State Significant Development Application (SSD 7348) for Oakdale West Industrial Estate at Kemps Creek

Key Assessment Issues – Oakdale West Estate	
Rural-Residential Interface	<ul style="list-style-type: none"> The setbacks on the southern boundary do not allow for appropriate landscaping or screening resulting in a poor interface with the rural areas to the south. Similar setbacks and treatments of the western boundary should be incorporated along the southern boundary. The extensive cut and fill proposed has little regard for the adjoining land uses and is not a suitable outcome. In addition, the retaining walls will be highly visual during the short-medium term while the vegetation is being established. The Visual Impact Assessment includes an assessment from a private residence on Bakers Lane. The assessment concludes that no mitigation measures are required given the proposed level changes. However the assessment indicates that the industrial building roofs will be highly visible which will result in undesirable glare for adjoining residents. These need to be further considered and addressed.

PRECINCT PLAN

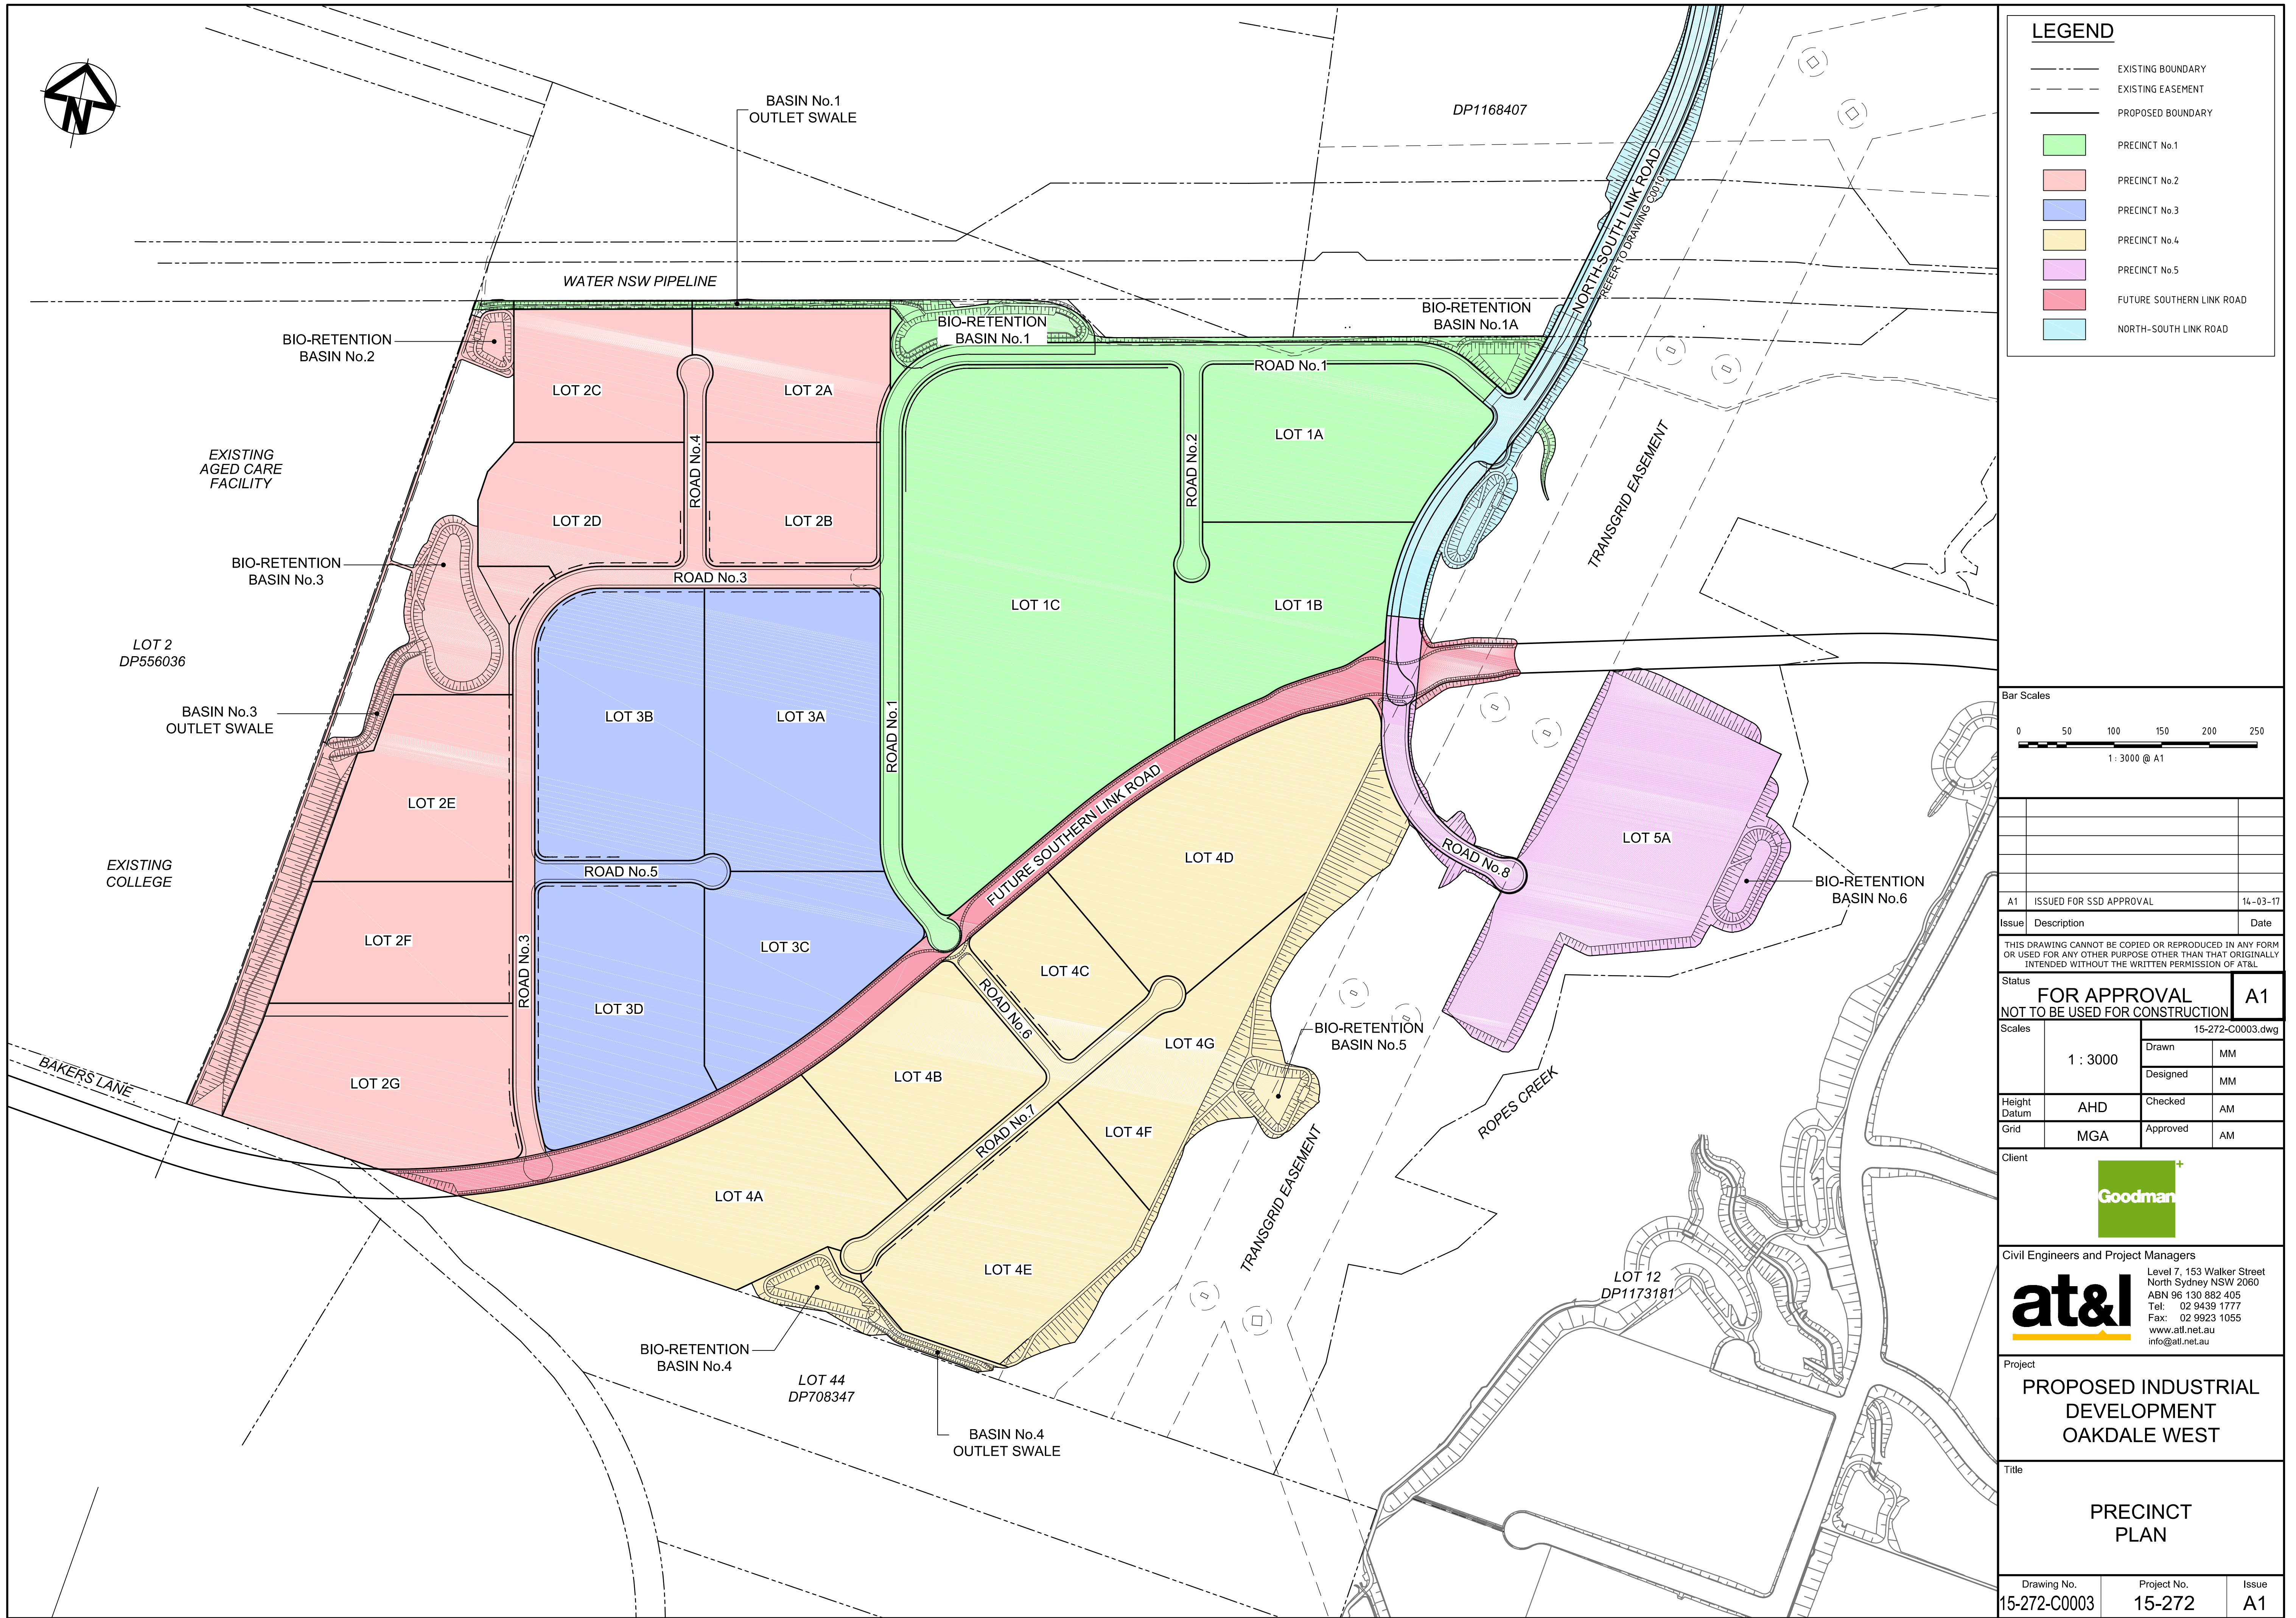
Road Network	<ul style="list-style-type: none"> • The future Southern Link Road showing a potential connection to Bakers Lane is not supported. Direct vehicular access to Mamre Road shall only be permitted at the signalised intersections with Erskine Park Road and the James Erskine Drive. Direct vehicular access to Erskine Park Road shall only be permitted at signalised intersection to Lenore Drive and at one combined intersection for the property north of Erskine Park Road and the eastern block for Lot 16 DP259146. No other direct vehicular access to these designated roads will be permitted as per Figure E6.10 – Erskine Business Park Traffic Works. In this regard, the Southern Link Road shall terminate at Estate Road 03. • Batters adjoining road reserves shall be a maximum 1 in 5 – not 1 in 4.

WESTERN BOUNDARY LAYOUT AND SECTIONS

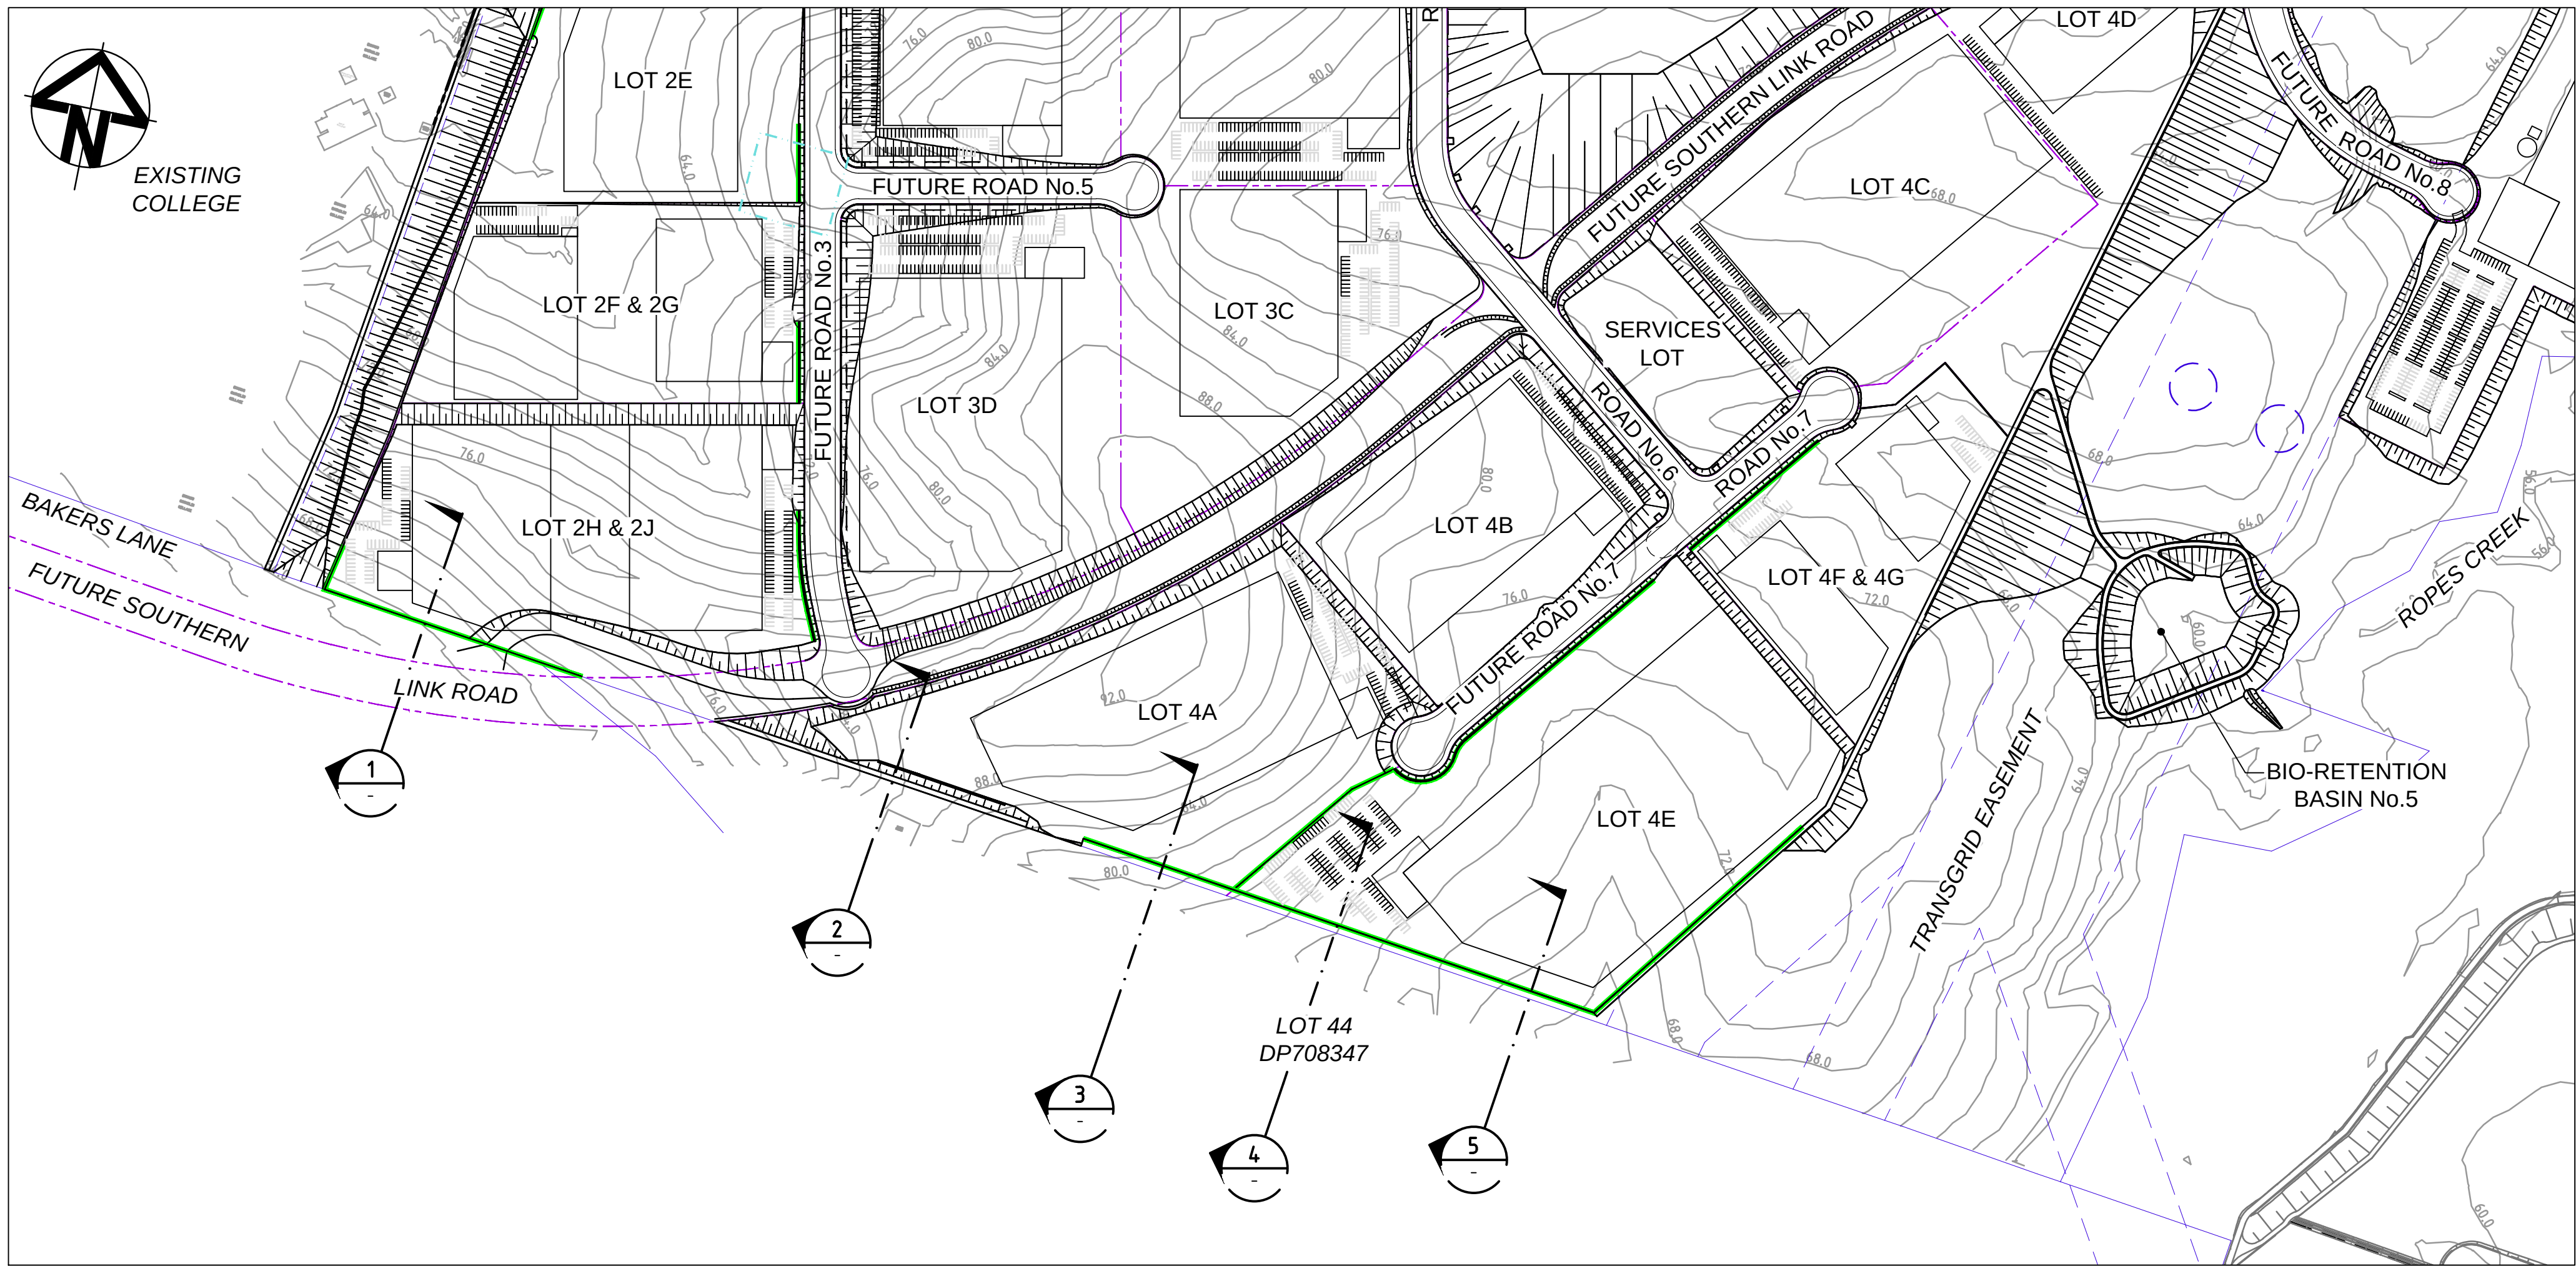
<p>clear through this application how and when development consent for the above stated remediation works was obtained, and this proposal does not seek consent for these works (a Remedial Action Plan has not been provided as required by clause 17 of SEPP 55). Further comment on this matter should be provided by the applicant.</p>
<i>Fill Material</i>	<ul style="list-style-type: none"> • The EIS indicates that only VEMN and ENM will be used and that the material will be screened and validated at the source. However, no information regarding the procedures that will be put in place to inspect the material when it arrives on site or to review the documentation to ensure that the material is suitable. As such, a "Fill Importation Protocol" should be provided prior to works commencing on site and detailed in the Construction Environmental Management Plan.
<i>Landscaping</i>	<ul style="list-style-type: none"> • The proposed street tree treatments are not supported. Ballast stone retains heat, which can cook the roots and impact on tree growth. • The landscape plan provides insufficient detail and is inconsistent in certain sections. • Sections of Estate Roads 1-6 have not been provided. As such, it cannot be confirmed that there is sufficient space within the verge for the proposed street trees species. • A steep batter is located on the southern section of the western boundary. Clarification is sought on the access and maintenance of the landscaping within this area. • Additional shrubs of a screening nature shall be provided within the landscaped setback area along the western boundary.
